**Consultation Response from KC,
Lead Local Flood Authority**

2025/93355 Land off, Woodward Court, Mirfield, WF14 0PY

Erection of 75 residential dwellings with associated landscaping, open space, highways and drainage infrastructure

Date Responded: 17th April 2026

**FLOOD ROUTING PLAN**

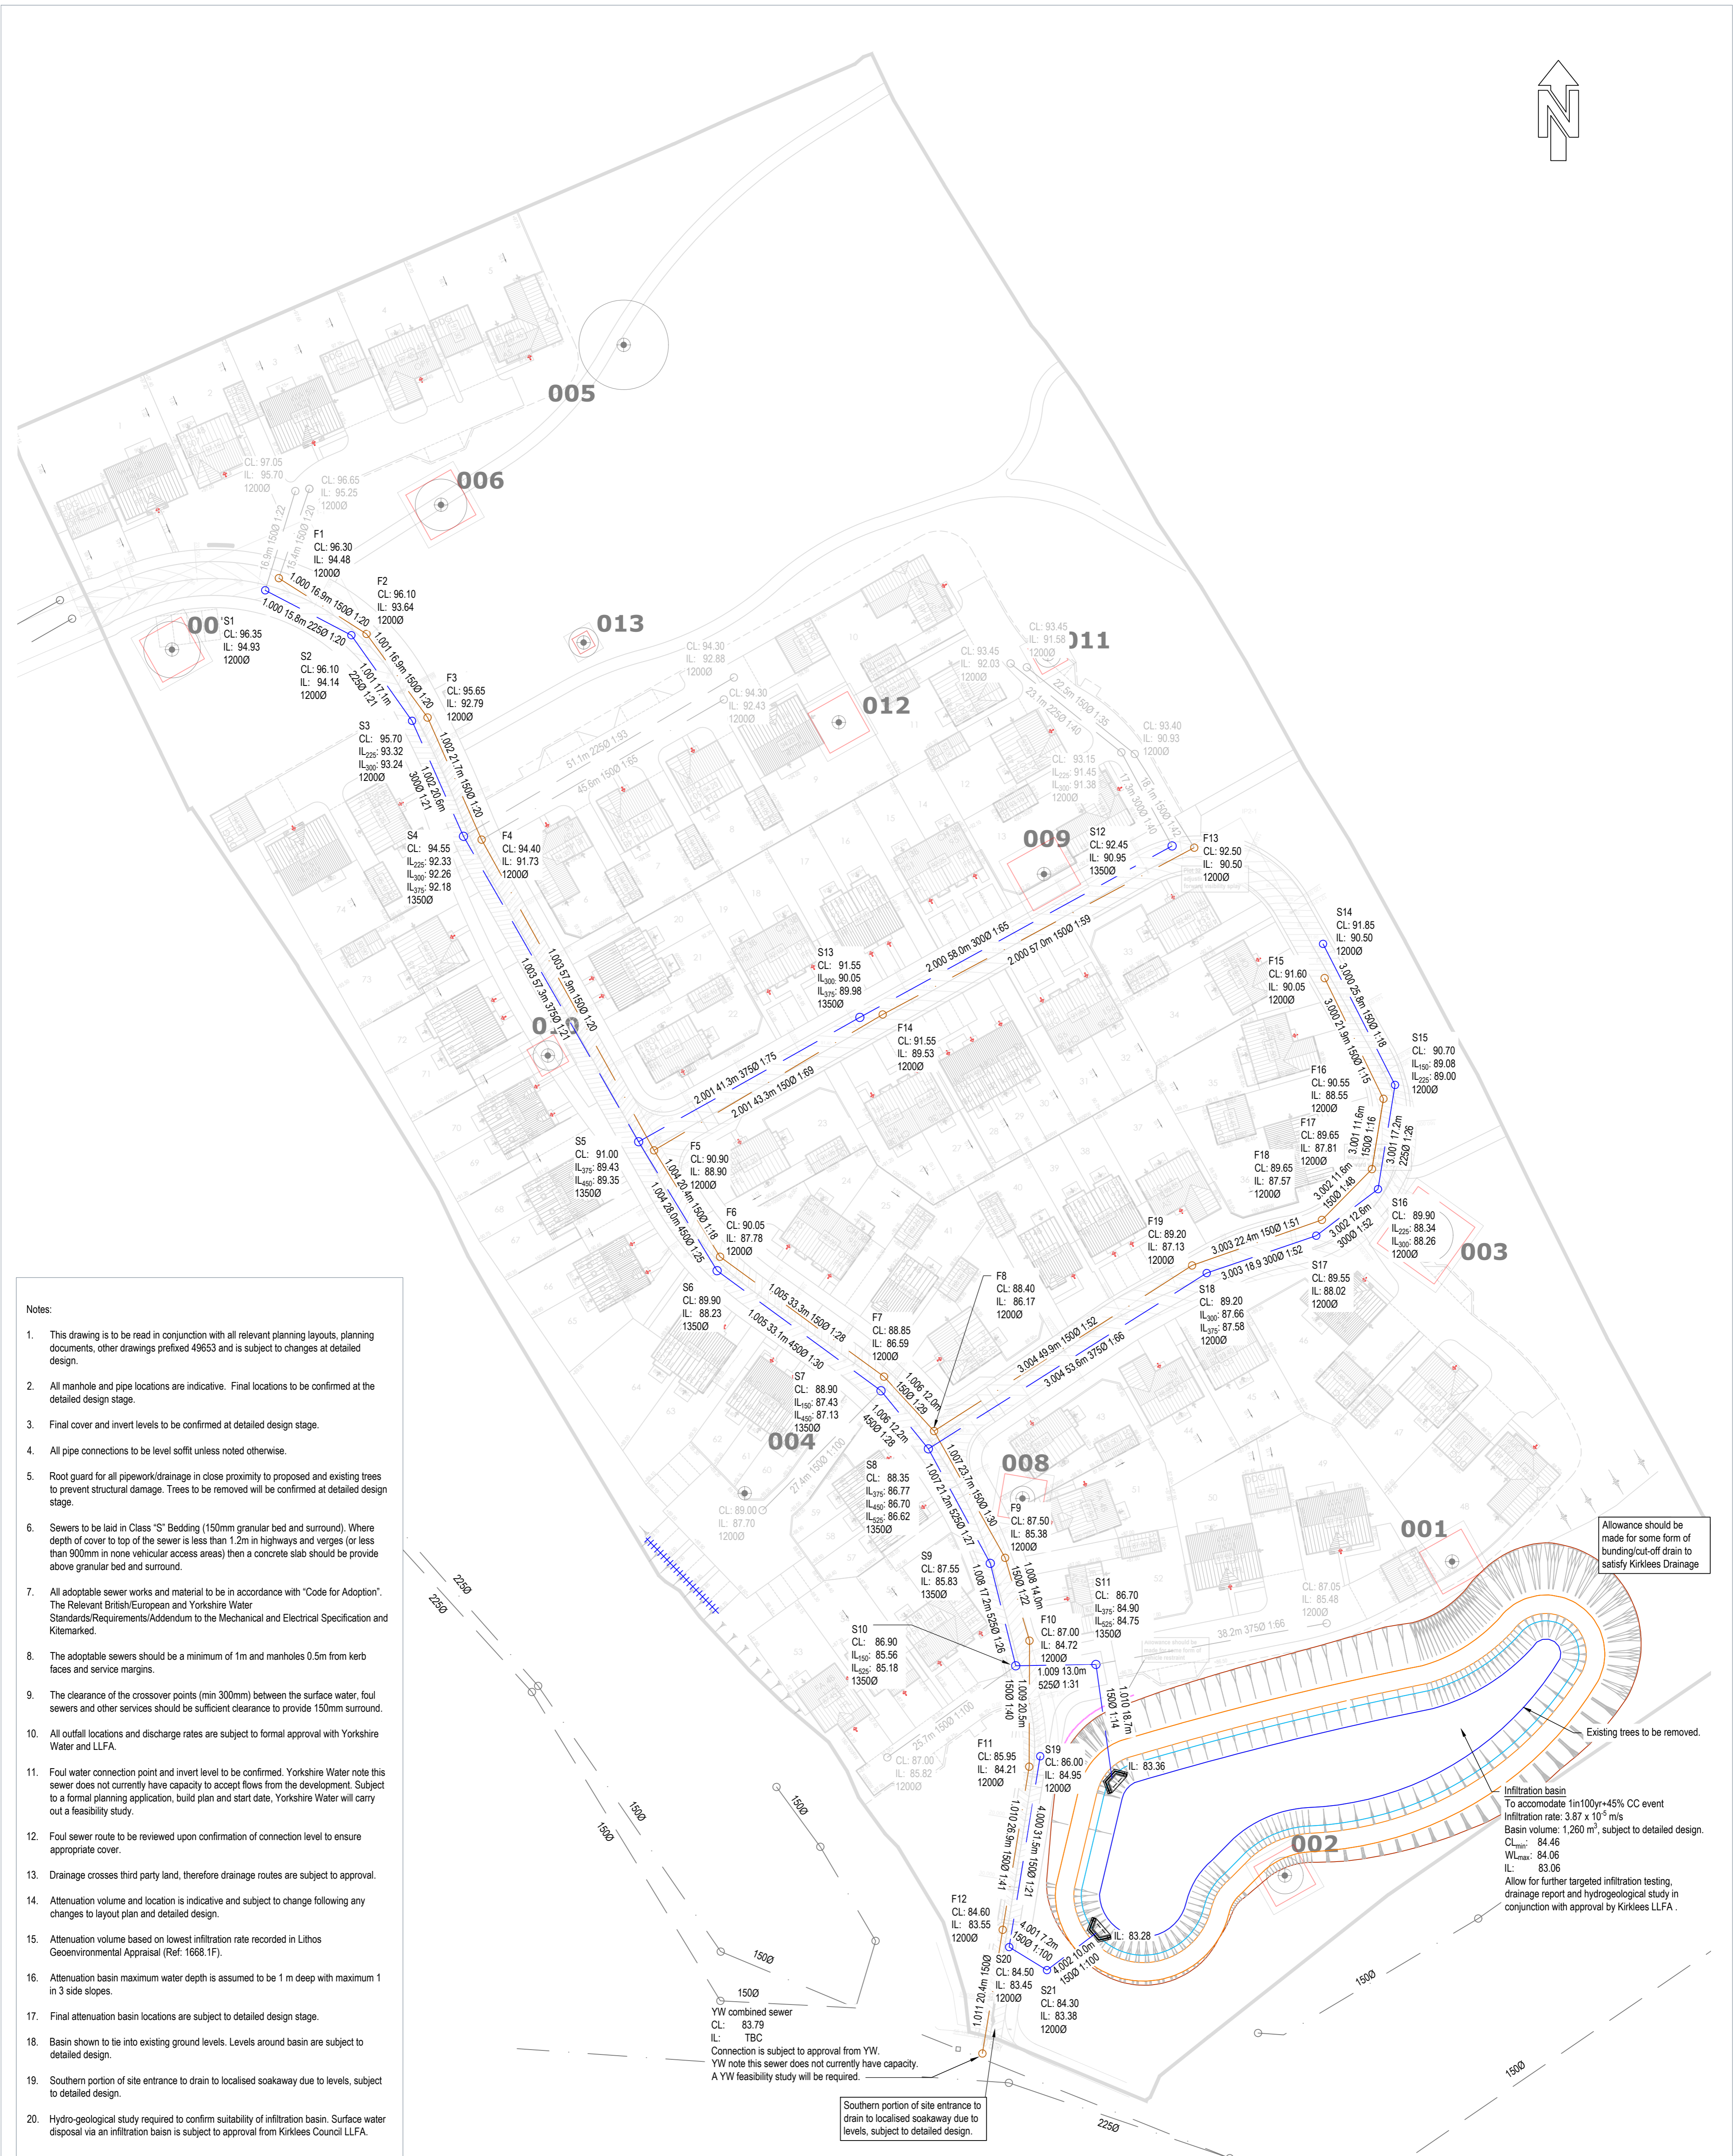
- It is clear from a recent Lithos submission that further testing, drilling and grouting of mine workings is expected including for an area around the proposed infiltration basin. We believe grouting and capping would affect previous infiltration results as voids are filled. The National Coal Authority should comment on the effects of soakaways on mine workings both in terms of distorting testing and long-term suitability of using this method.

- We recommend that Kirklees Local Planning Authority takes independent geotechnical advice on this matter.
- As stated previously, establishing a suitable connection for surface water off site (PLAN B) is the only instance where we would recommend conditional approval as there would be an agreed drainage method available to take this forward even with on going research for infiltration techniques.
